City of Portland, Maine - Building or Use Permit Application
 389 Congress Street, 04101 Tel: (207) 874-8703, Fax: (207) 874-8716

Permit No: 05-1515	Issue Date:	CBL: 310 F017001
------------------------------	--------------------	----------------------------

Past Use: Single Family	Proposed Use: Single Family demo existing garage and replace w/ 2 car garage	Permit Fee: \$237.00	Cost of Work: \$23,549.00	CEO District: 5
Proposed Project Description: Demo existing garage and replace w/ 2 car garage		FIRE DEPT: <input type="checkbox"/> Approved <input type="checkbox"/> Denied	INSPECTION: Use Group: Type	
		Signature:	Signature:	
PEDESTRIAN ACTIVITIES DISTRICT (P.A.D.)				
Action: <input type="checkbox"/> Approved <input type="checkbox"/> Approved w/Condition <input type="checkbox"/> Denied				
		Signature:	Date:

Dept: Zoning	Status: Approved with Conditions	Reviewer: Jeanine Bourke	Approval Date: 11/15/2005
Note:	Ok to Issue: <input checked="" type="checkbox"/>		
1) Approved using Sec. 14-433 to decrease the rear setback to a min. Of 5' due to the slight increase in the footprint of the nonconforming garage			
Dept: Building	Status: Approved with Conditions	Reviewer: Jeanine Bourke

50' ±
PLOT PLAN

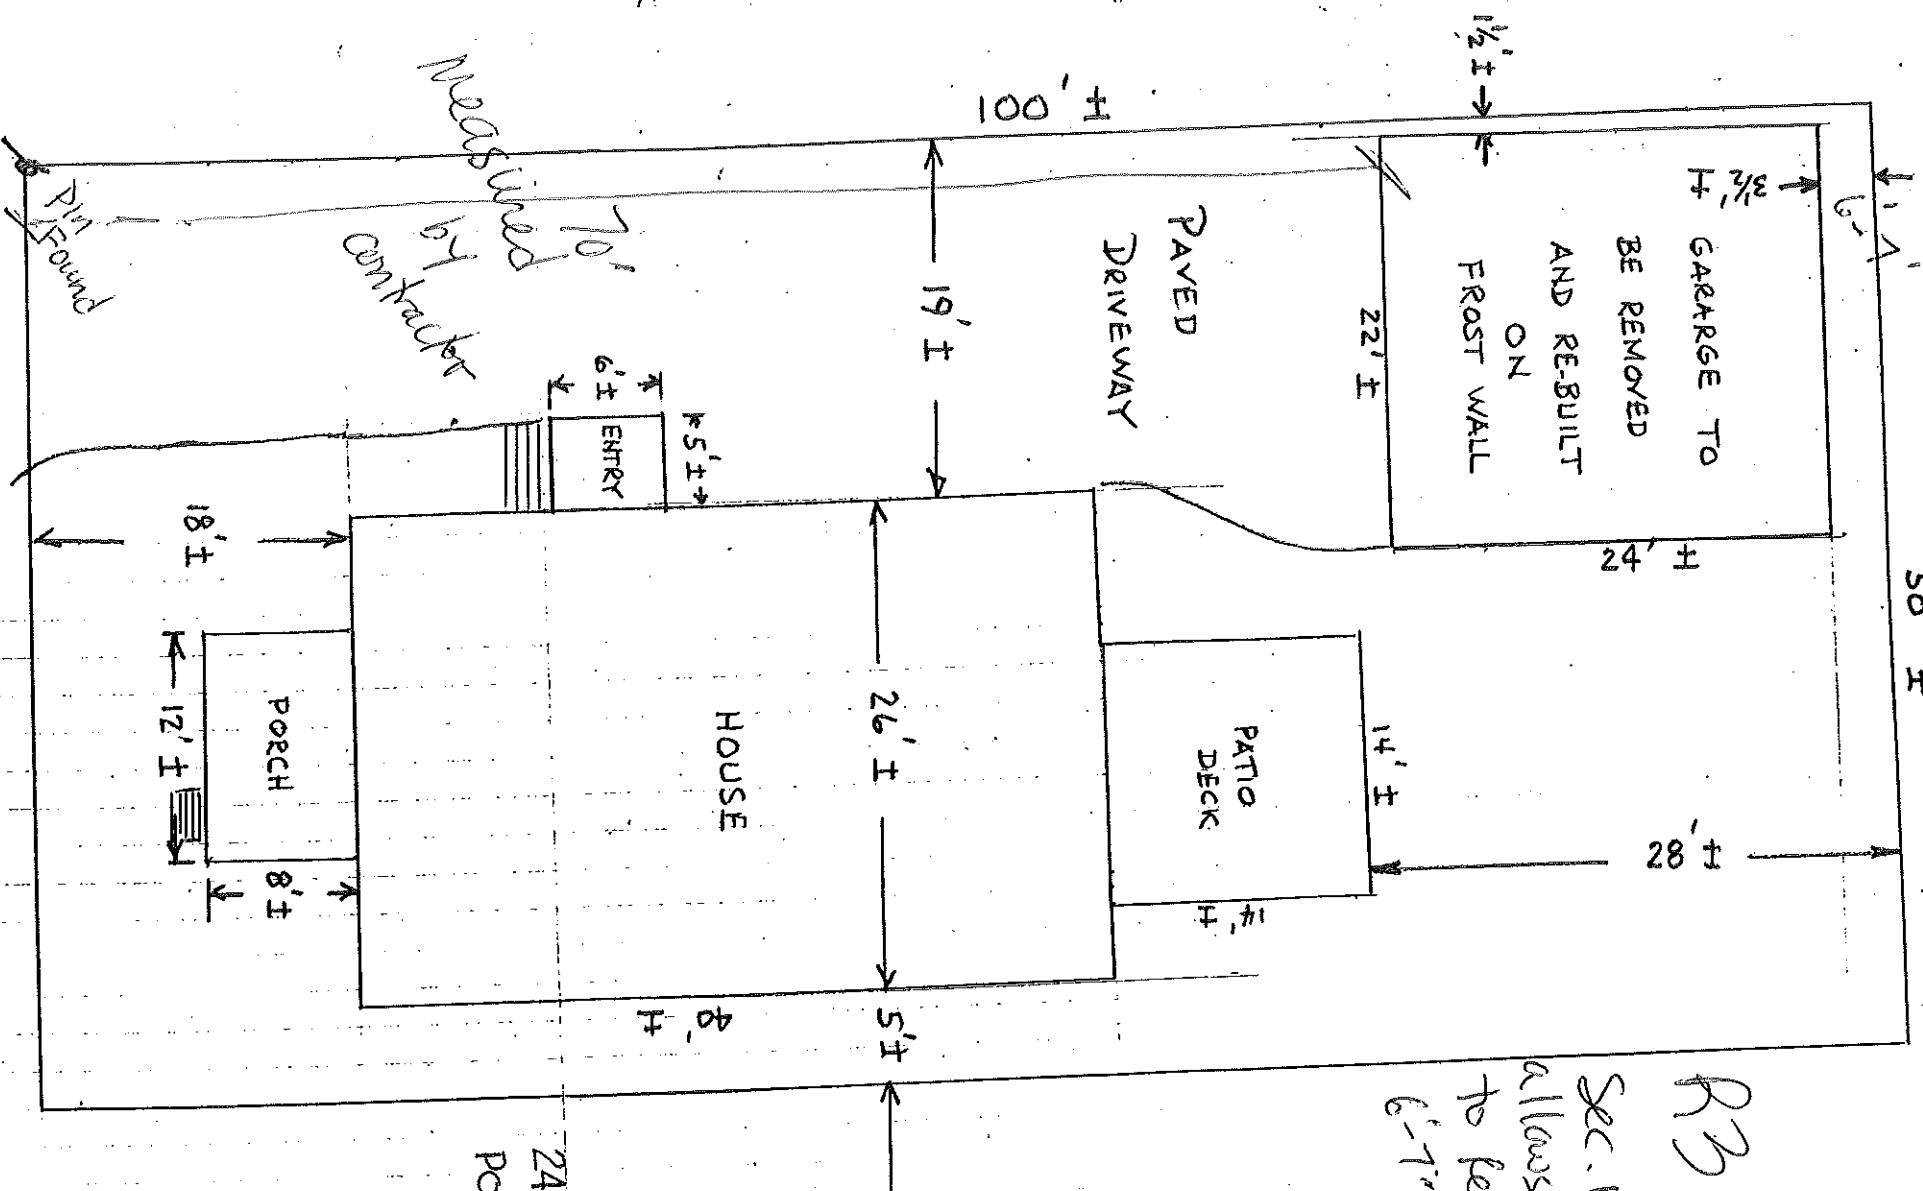
Comments:
11/02/2005-jmb: Left vm w/owner & contractor that the garage dimensions are not consistent w/the assessors record, scheduled pre-demolition inspection
11/03/2005-jmb: Pre-demo shows the existing garage is smaller than the proposed garage, and the shed extension is shorter than the garage roof, left vm w/owner & contractor.
11/07/2005-jmb: Spoke w/Reggie B. About the new garage being non-conforming, will research microfiche for permits on existing and meet w/Marge for ruling.
11/07/2005-jmb: Reggie B. Called back to inquire if there was any exception, I said I would research for record of the rear bump out, and speak w/ Marge about Sec. 14-433 as the lot is limited in where this garage could be located and the owner has a truck & van (18') that cannot be stored in the existitng garage.
11/09/2005-jmb: Left vm w/Reggie B. About research & asked if there was a mortgage survey showing the garage extension. He will check w/owners. Also explained exception possibility. He called back to say he found the left front property marker and measured 70' exactly to the front of the existing garage. With a 24' garage, this would give a 6' rear setback based on 100'. He agreed to move the garage forward 1' just to make sure. He will get back on 11/14 w/info.
